A46 Newark Bypass

Statement of Common Ground with Newark and Sherwood District Council 'NSDC'

**Statement of Common Ground with
Newark And Sherwood District Council**

Regulation Number:	Regulation 5(2)(q)
Planning Inspectorate Scheme Reference	TR010065
Application Document Reference	7.30
Author:	A46 Newark Bypass Project Team, National Highways

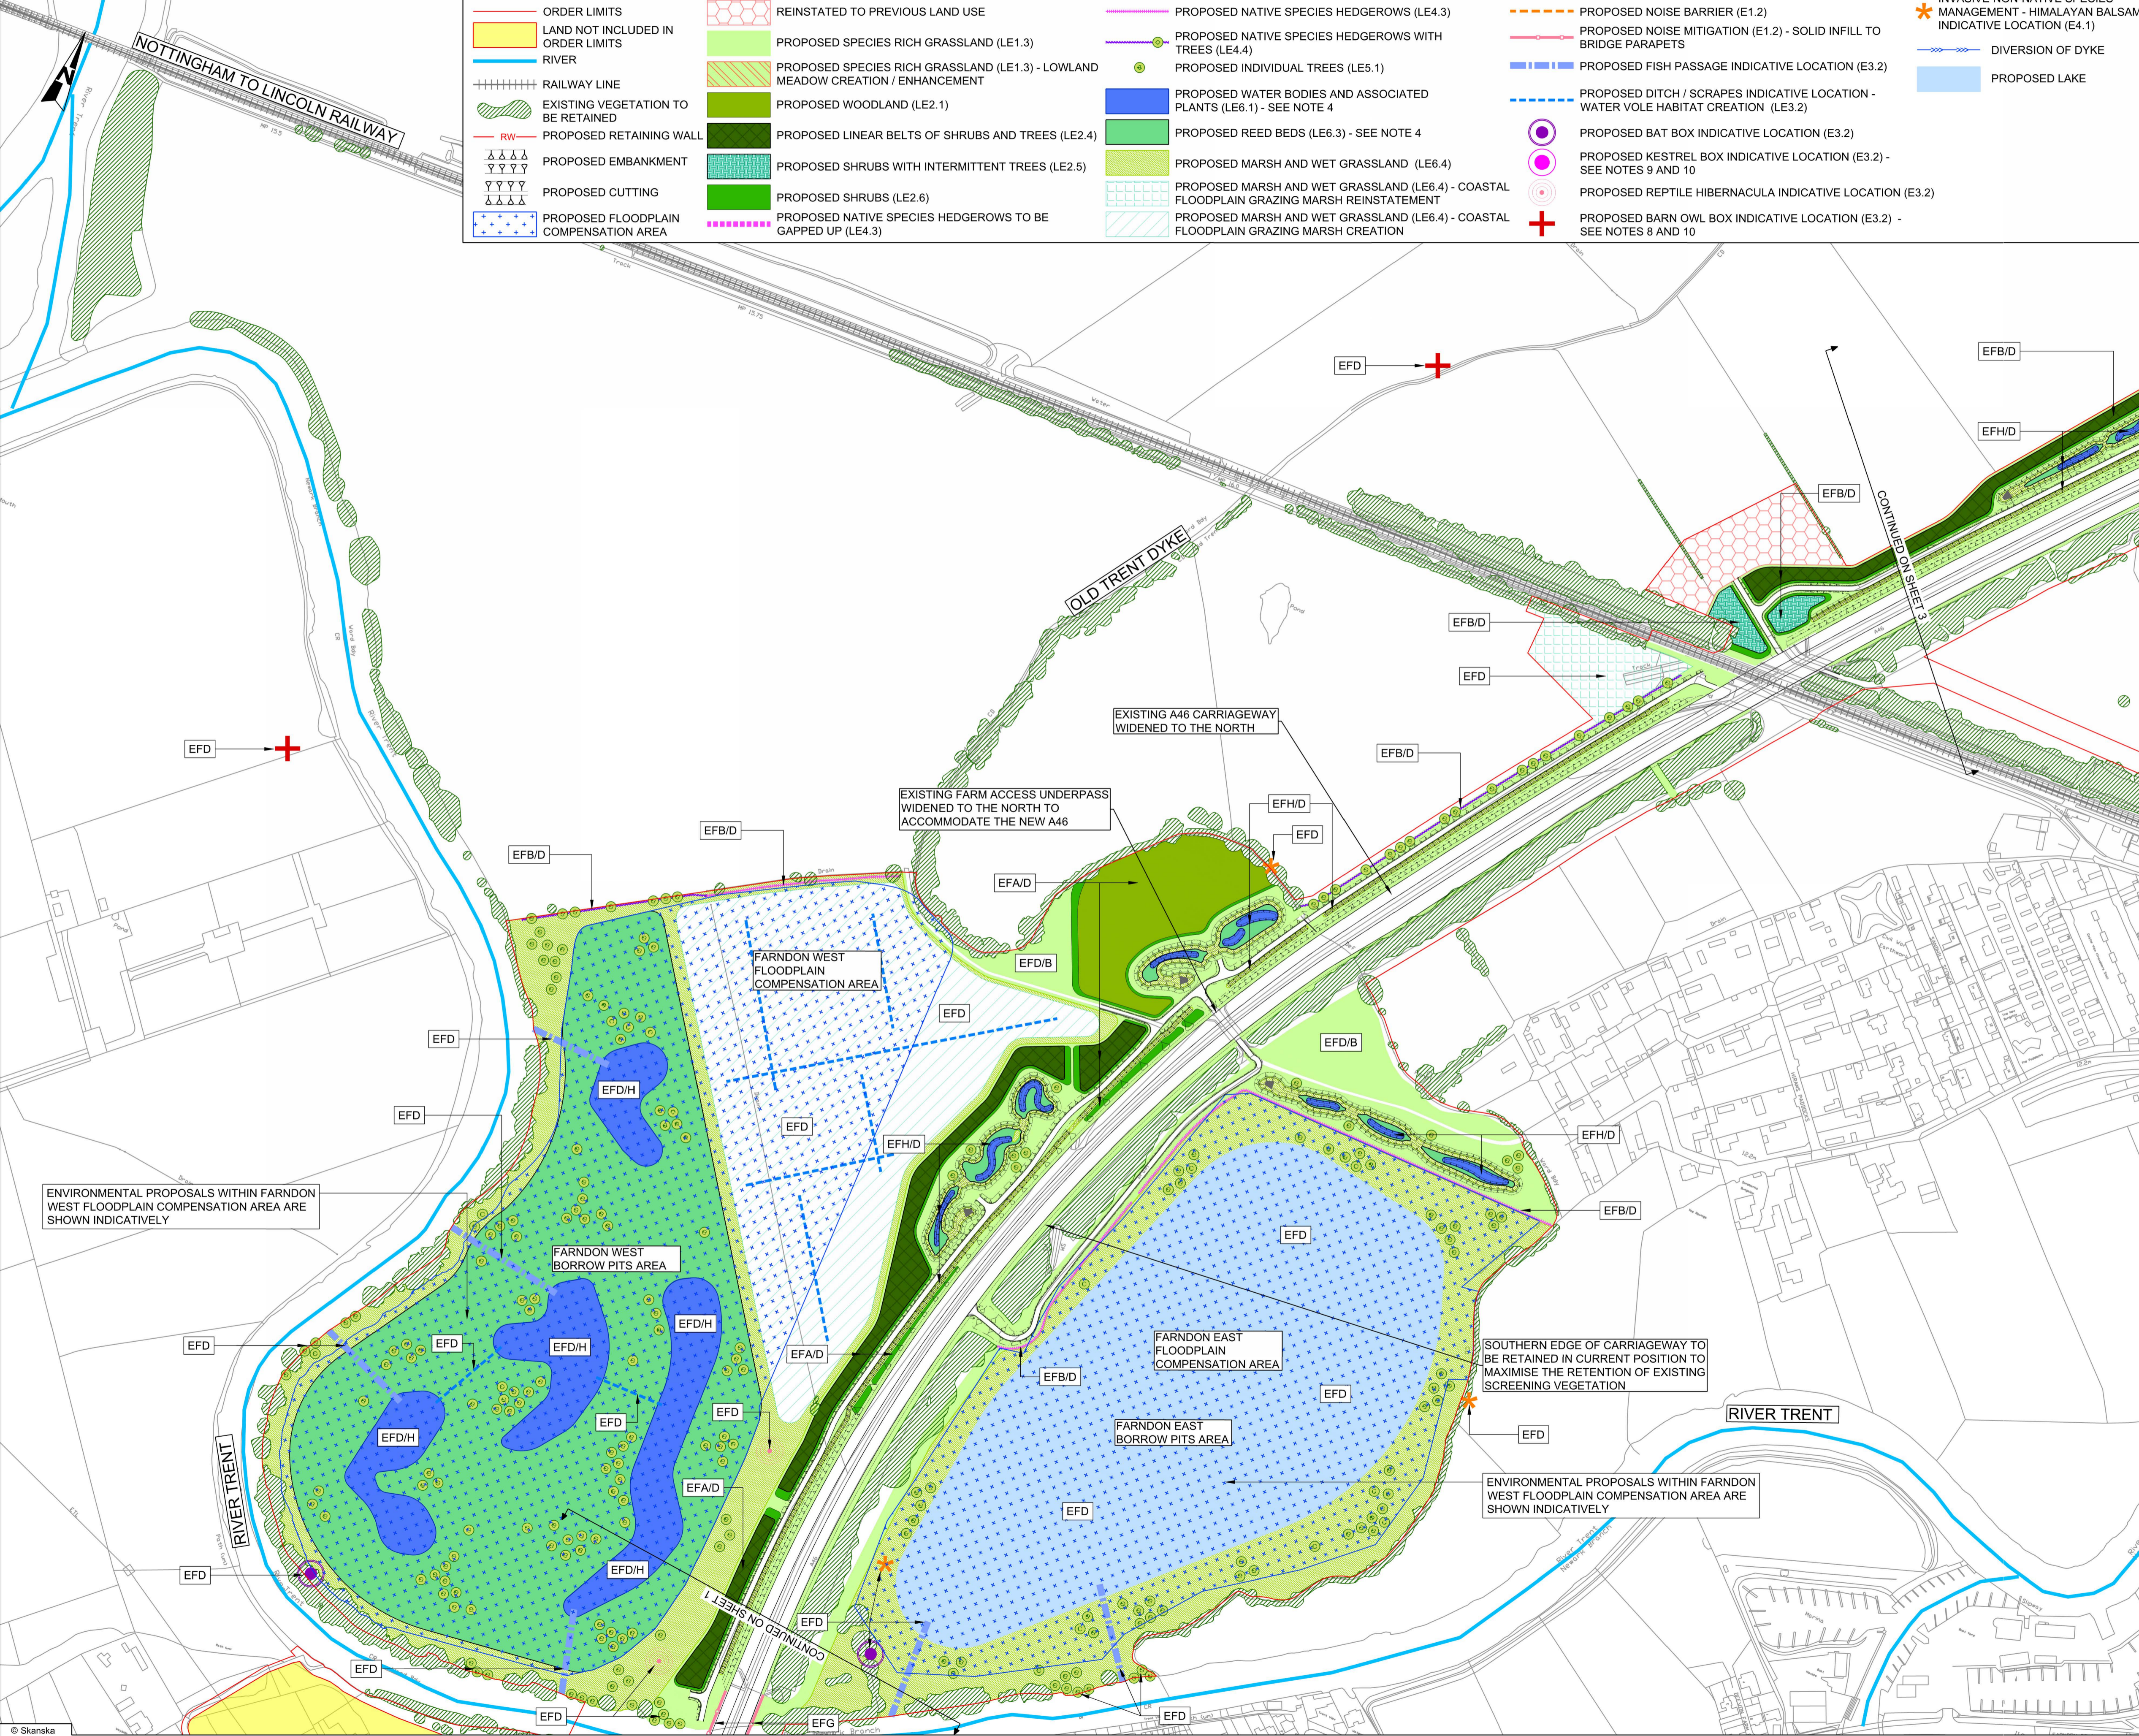
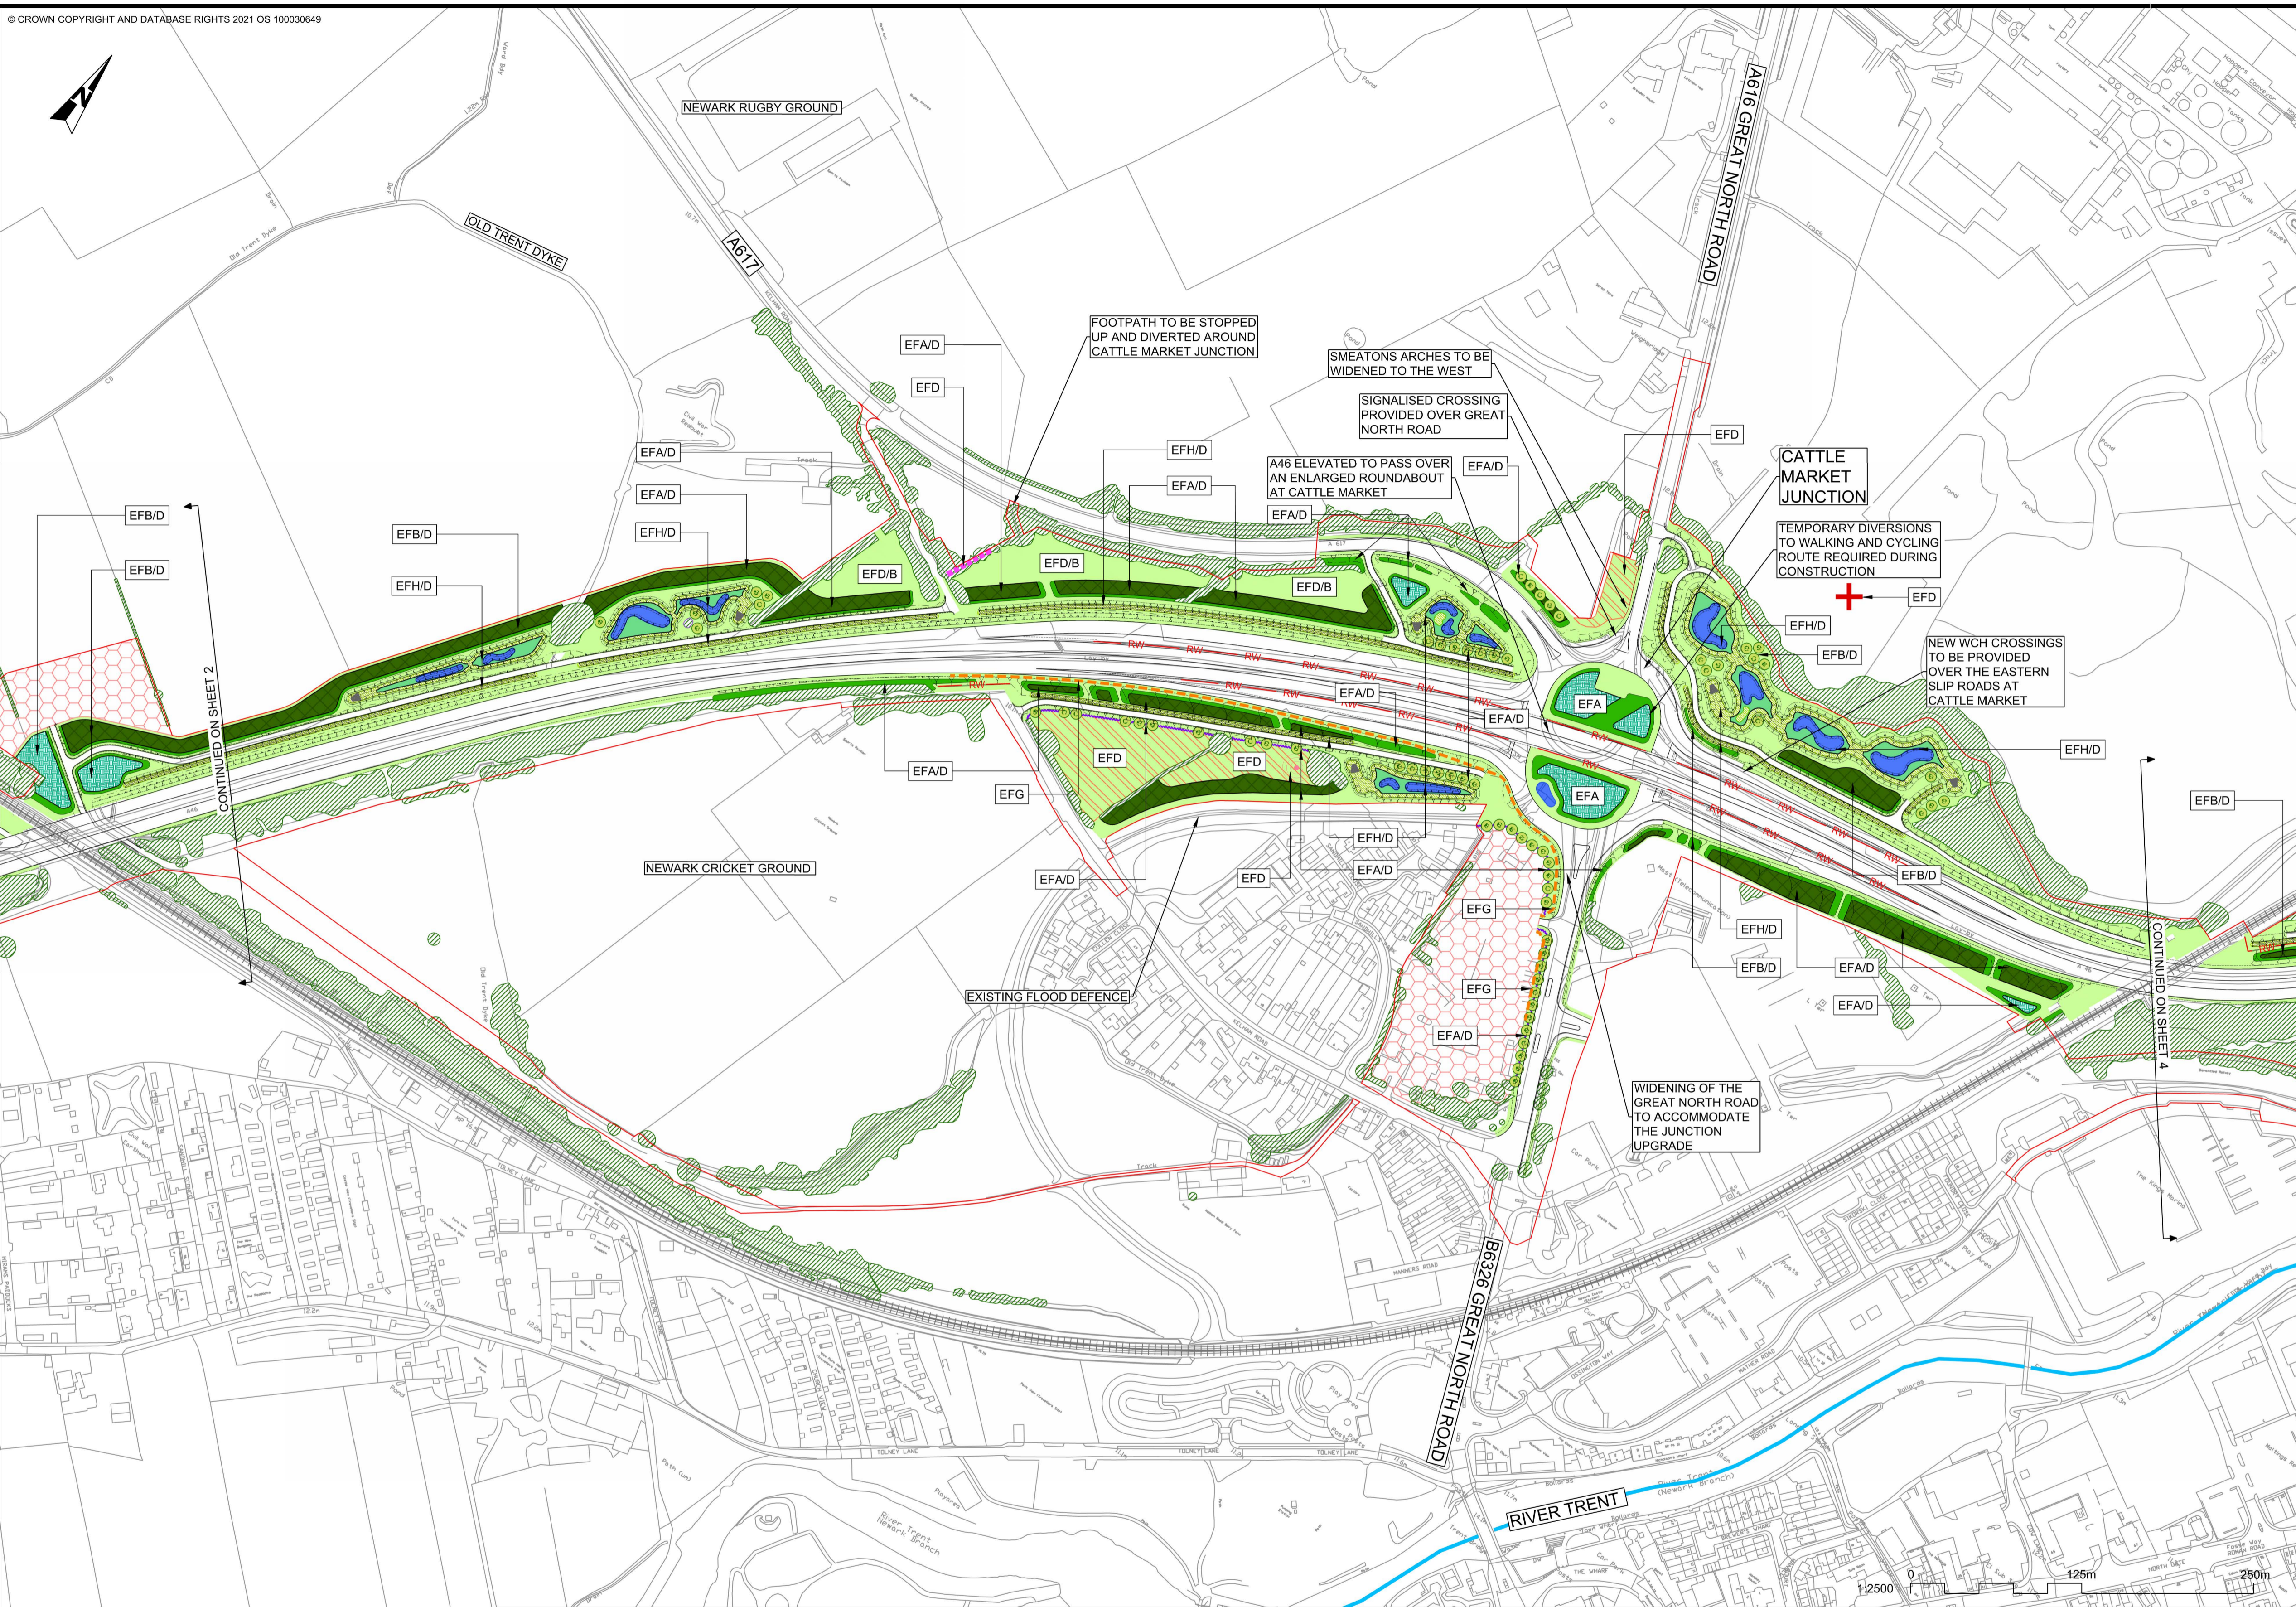
10.	Design (including justification for any flexibility being sought)	<p>Chapter 2 The Scheme of the Environmental Statement [APP-046]</p> <p>6.2 Environmental Statement - Figure 2.3 Environmental Masterplan [AS-026]</p>	<p>Cattle Market flyover</p> <p>On the fly-through video the structure of the elevated over-pass at the Cattle Market junction appears as a stark and imposing concrete structure. This may be in part due to the animation which depicts it as being very bright in colour and therefore standing out vividly. The Council would want to understand proposals to ensure the visible impact of the final structure is minimised and/or mitigated as far as practicable.</p>	<p>Consideration has been given to the aesthetic finish of the structure during the design development to help to reduce the visual prominence of the structure and to reflect finishes on existing structures such as that of Smeaton's Arches just to the north of the new junction. Further details of these can be found within Chapter 2 The Scheme of the Environmental Statement [APP-046] and 6.2 Environmental Statement - Figure 2.3 Environmental Masterplan [AS-026].</p> <p>Planting of trees and shrubs has also been considered and incorporated wherever feasible to help break up the visual mass of the structure, with planting softening the built form and aiding screening over time, particularly from properties such as those in Sandhills Park affording near distance views.</p> <p>The assessment of landscape and visual effects and associated design and mitigation measures are described in 6.2 Environmental Statement - Figure 2.3 Environmental Masterplan [AS-026] and presented in 6.2 Environmental Statement - Figure 2.3 Environmental Masterplan [APP-026].</p>	Under Discussion	16/10/2024
